Address: 7, Woodward Court, Mirfield, WF14 0PY

Application number: 2025/93355	
What is the application for?:	Erection of 75 residential dwellings with associated landscaping, open space, hi
Address of the site or building:	Land off, Woodward Court, Mirfield, WF14 0PY
Postcode:	LS15 8ZB

User comments

WOODWARD COURT, MIRFIELD

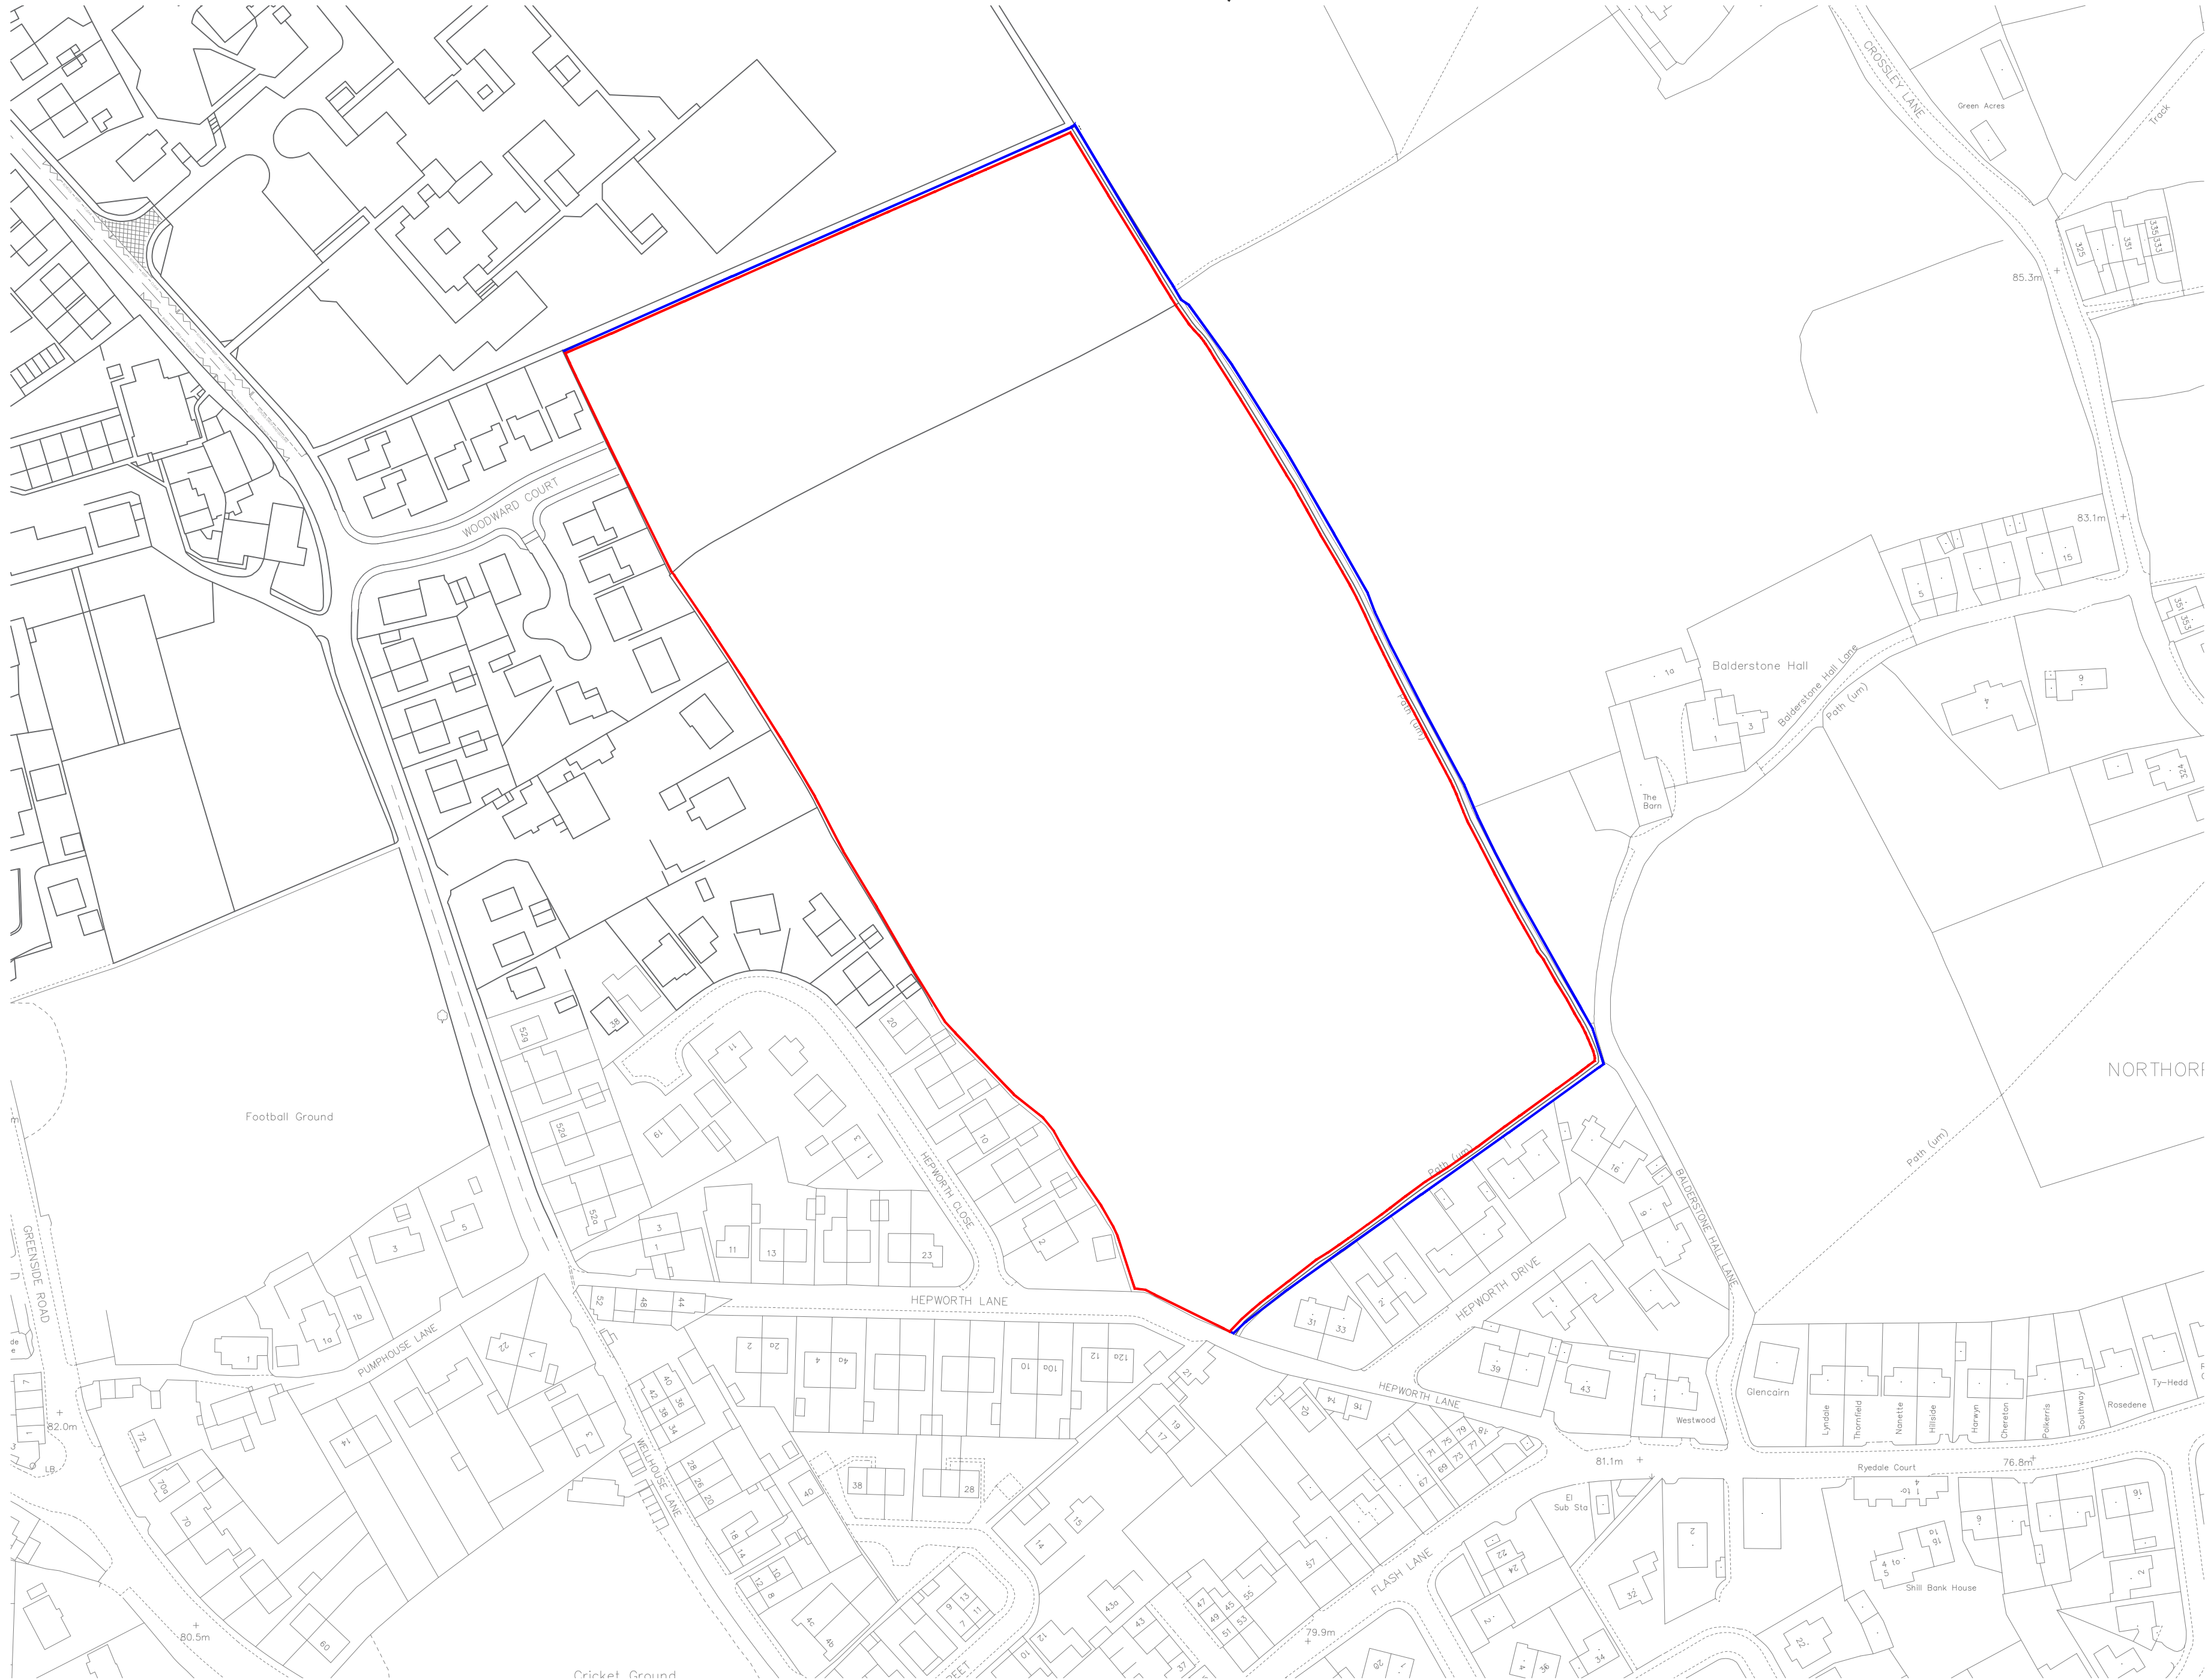
Specifically, I object to the positioning of the proposed utility electricity substation and the adjacent communal school drop-off car park directly against a residential property boundary (7 Woodward Court). While I understand the council's desire to alleviate school traffic on local Mirfield roads, the decision to group these two high-impact utilities together directly flush with an established private garden boundary represents an unacceptable failure of design under Kirklees Local Plan Policy LP24.

A school pick-up/drop-off zone introduces intense, concentrated peaks of noise pollution (slamming doors, shouting, shouting over traffic) and hazardous air pollution from idling vehicles right at my fence line and back door. This is a severe invasion of privacy and directly deprives me of the quiet enjoyment of my amenity space. The garden will be a no go zone during school pick up times. Parents who currently park on Woodward Court often leave engines idling/running for up to 45 minutes. Putting a school drop off car park within 1 metre of the side of a residential property and its back door and garden is not acceptable. The hazardous air pollution is a health issue. It will be directed straight into my garden, and directly into my back door.

The electricity sub station can be accessed 24 hours a day by heavy vehicles, and potentially noisy maintenance and repair work. Again this deprives me of the current amenity of quiet use of my house and garden that I currently enjoy

I am concerned that low level humming will also be a nuisance, and will impact on my current amenity. At its closest point the Electricity substation is 1 metre from my garden. Using the plans provided I calculate that the electricity sub station will be around 7 metres from the rear of my property - far too close. This is unnecessary and the sub station was previously planned to be apart from both new and existing residential properties.

To layer a high-turnover school drop off car park, with an associated upgraded footpath directly behind my property, and directly next to a 24/7 humming electrical substation kiosk creates an intensely industrialised 'service yard' impact on an existing residential boundary. It is an unmitigated cumulative nuisance.

Furthermore, introducing high-volume pedestrian child activity directly adjacent to a high-voltage substation perimeter fence represents an unnecessary site safety risk.

The sub station was located apart from both new and existing residential properties on the earlier plan Both the car park and the Electricity Substation should be relocated internally, deeper within the masterplan or flanked entirely by the new build access roads and internal green buffers, protecting existing boundary holders. By relocating the car park, the developers can overcome the poor sightlines mentioned in the Road Safety audit, and the tight turn into the car park. The car park, if located more as part of the development, can then become more of an amenity for the wider housing estate, rather than specifically for school drop off.

I urge Kirklees Council to refuse this specific layout and demand that the applicant submits a revised layout plan relocating the communal car park and substation internally, away from all established residential boundaries.
